20th December 2010

Our Ref: FP/242/10/NMA

**Application for a Non-Material Amendment following a grant
of planning permission FP/217/08
4 Felpham Road, Felpham**

PROPOSED SOUTH ELEVATION

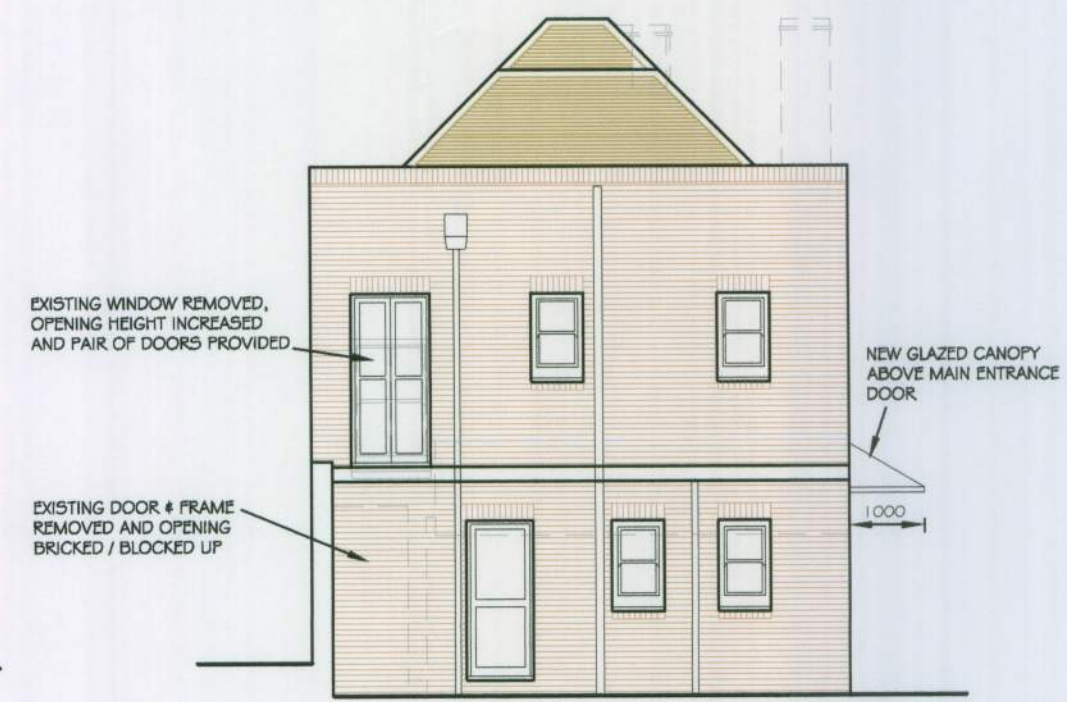
The changes identified from the approved plan, namely the change in window style/position and increase in height of the parapet wall on the south elevation and removal of zinc standing, change in materials from brickwork to render to match the existing property and change from 2 metre height opaque glazed screen to first floor balcony to close boarded timber screen on the east elevation would in total contribute to a material alteration in the appearance of the building and in a development that would look significantly different from that approved in the street scene. The alterations cannot therefore be accepted as a Non-Material Amendment.

I trust this information is of assistance. Without prejudice, should you wish to pursue the matter further, I would suggest a planning application is submitted for the proposed alterations.
